Application number 2022/62/93154/W Land at Penistone Road, Fenay Bridge, Huddersfield, HD8 0AW

Erection of 68 dwellings with associated access, parking, open space, landscaping and infrastructure works (including installation of surface water attenuation tank).

Green Alert in Lepton (GAIL) is recognised by the Council as a non-statutory consultee and representative of the Local Community on matters relating to the Local Plan. This consultation response is submitted on behalf of GAIL and should be read in conjunction with our previous submissions id 967502 and id 995682 and id 997991

P1	Preliminary - Initial Issue	
Project: FENAY BRIDGE		
Client: NEWETT HOMES		
Drawing: KIRKLEES REFUSE VEHICLE SWEEP PATH ANALYSIS		
Drawn By: MSF	Date: 05/09/2023	
Checked: JF	Scale: 1:500	A3
Drawing No. AMA/21312/ATR013.2		Rev. -

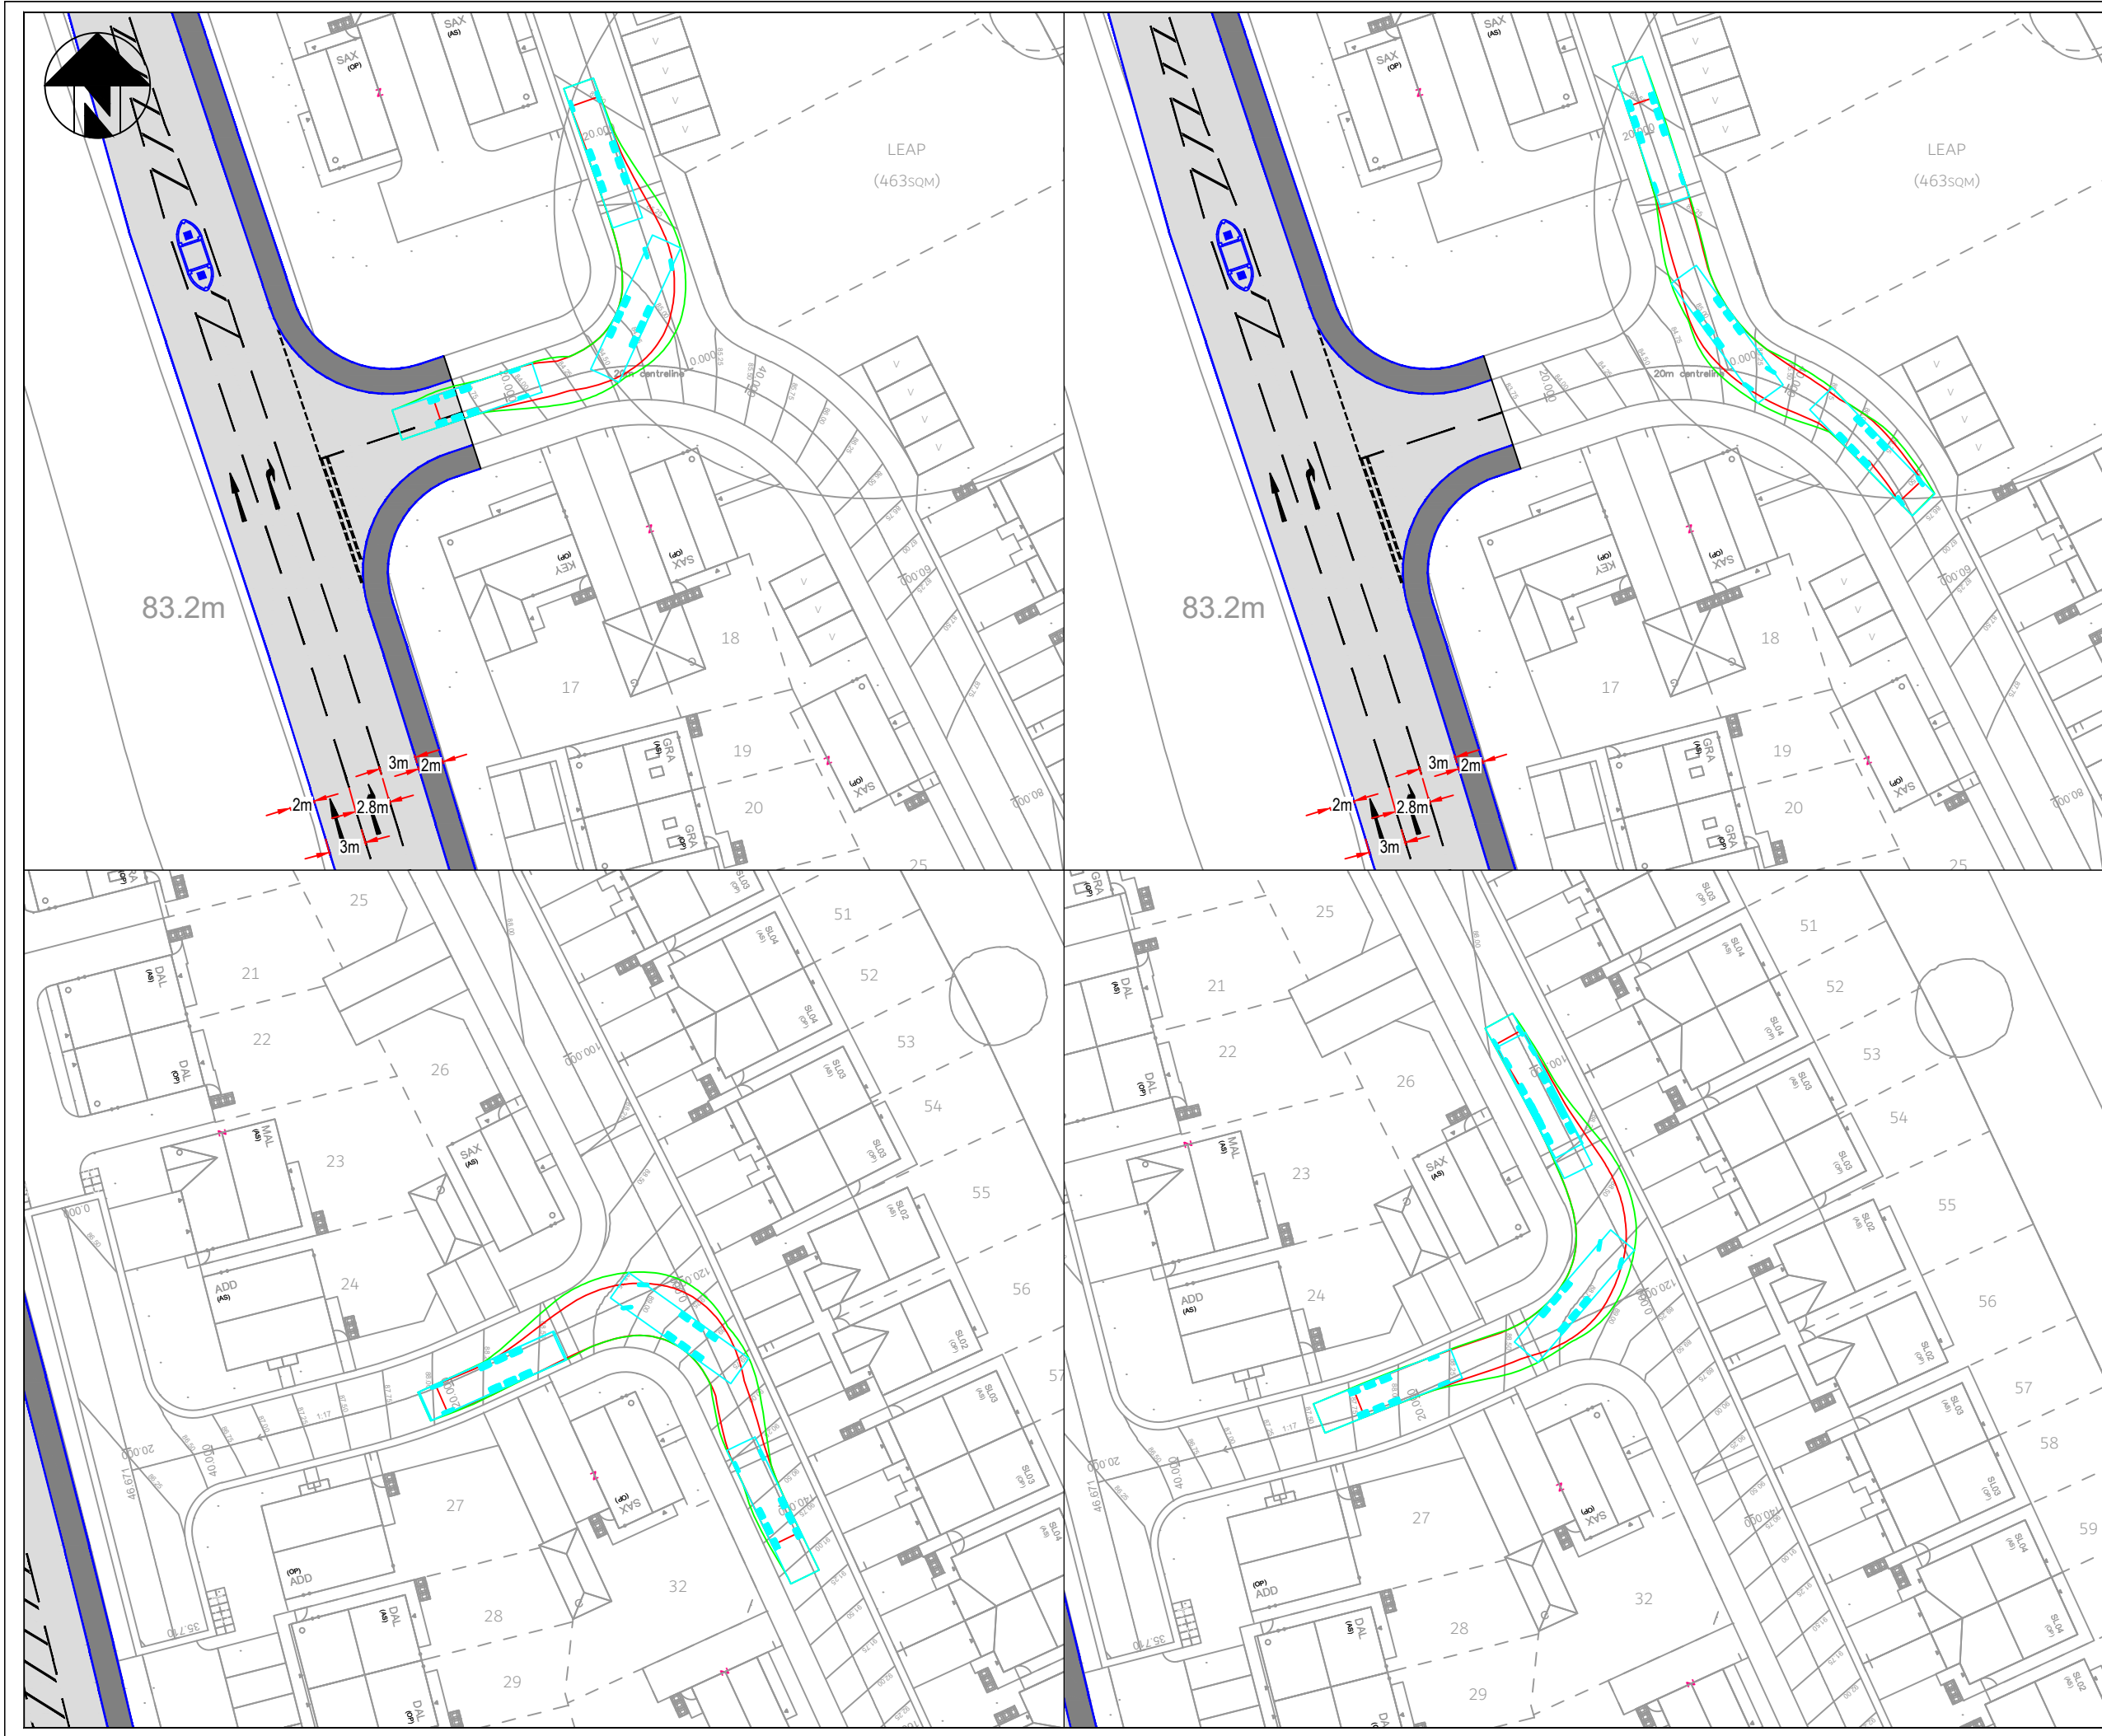
1.3 It is difficult from the designs submitted by the applicant to determine how much of the proposed tank will be visible from above ground. What is absolutely clear however is that to service the tank will require a swept access path of between 3 to 4 mts wide and approx 98mts long. This will clearly be visible.

1.6 GAIL would argue that the definition does not extend to making permanent changes to green belt land and that paragraph 150 of the NPPF was never intended to allow for such permanent changes to be made. **It is clear from the proposals that include a significant swept path track, above ground access points for tank servicing and other infrastructure requirements that the changes to the green belt will be permanent, will materially affect the openness of the green belt and as such is an inappropriate use of this green belt land.**

1.8 GAIL is therefore of the opinion that the Council should require the applicant to develop a solution that deals with surface water management within the site itself and not a solution that requires extensive and inappropriate use of green belt land.
